From: [REDACTED]
To: [A303 Stonehenge](#)
Subject: Summary of Oral Representations made at Issue Specific Hearing 6 on Behalf of West Amesbury Farms and Mrs.P.M.Sandell
Date: 21 June 2019 22:41:02

Here is the summary of the representations made at Issue Specific Hearing 6 on behalf of my clients

ANNEX E
Plan showing where Stonehenge Road should be closed at its junction with Woodford Valley Road

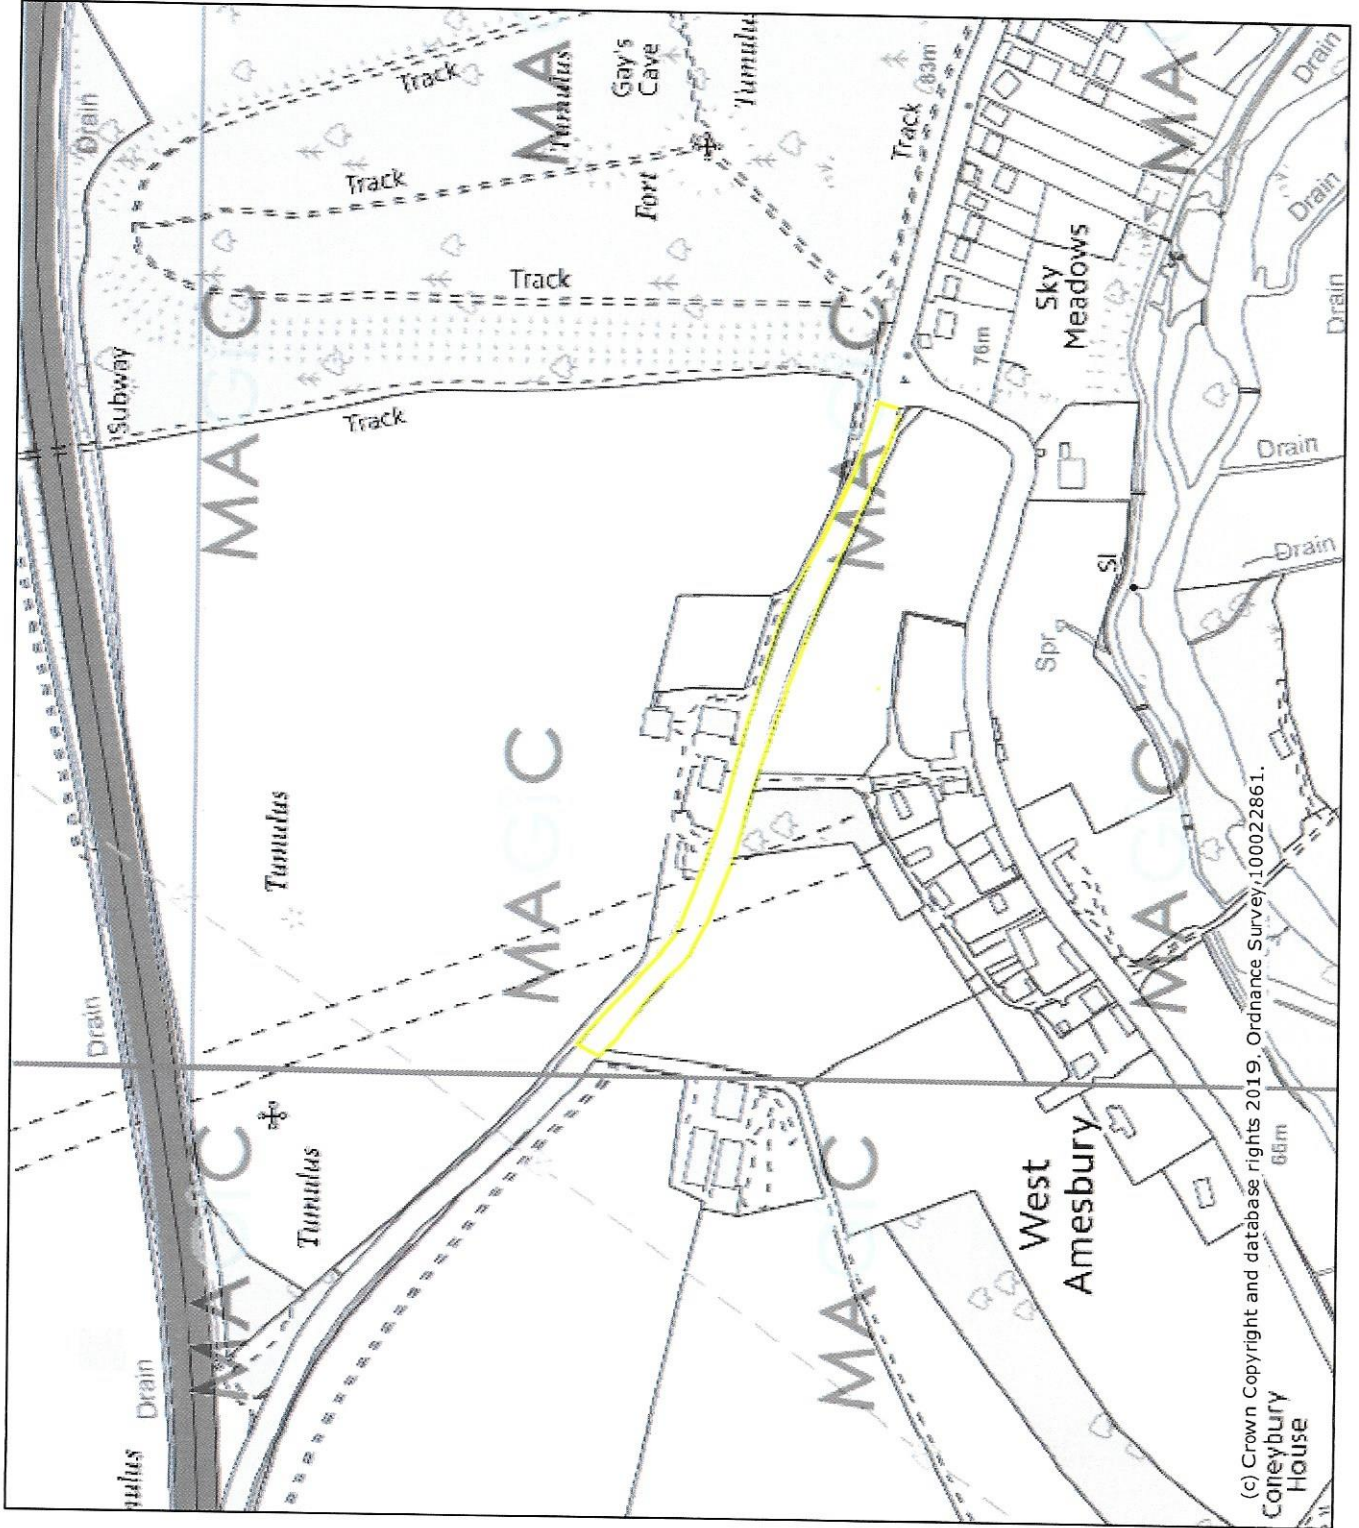
Examiners were reminded that on the accompanied site visit they would have seen for themselves the intended stopping point of Stonehenge Road immediately beyond the entrance to West Amesbury Farm which will create a highway ending in a cul de sac and which goes nowhere which will cause long term problems for West Amesbury Farms obtaining access to the property where all harvested crops are brought to for storage before sale and removal from farm. Fears were expressed if the entrance was blocked by tour operators or mini busses bringing tourists to a point where they could then use other means to gain a free view of the stones. The point was made again that the stopping up point should be at the junction of the Woodford valley road .
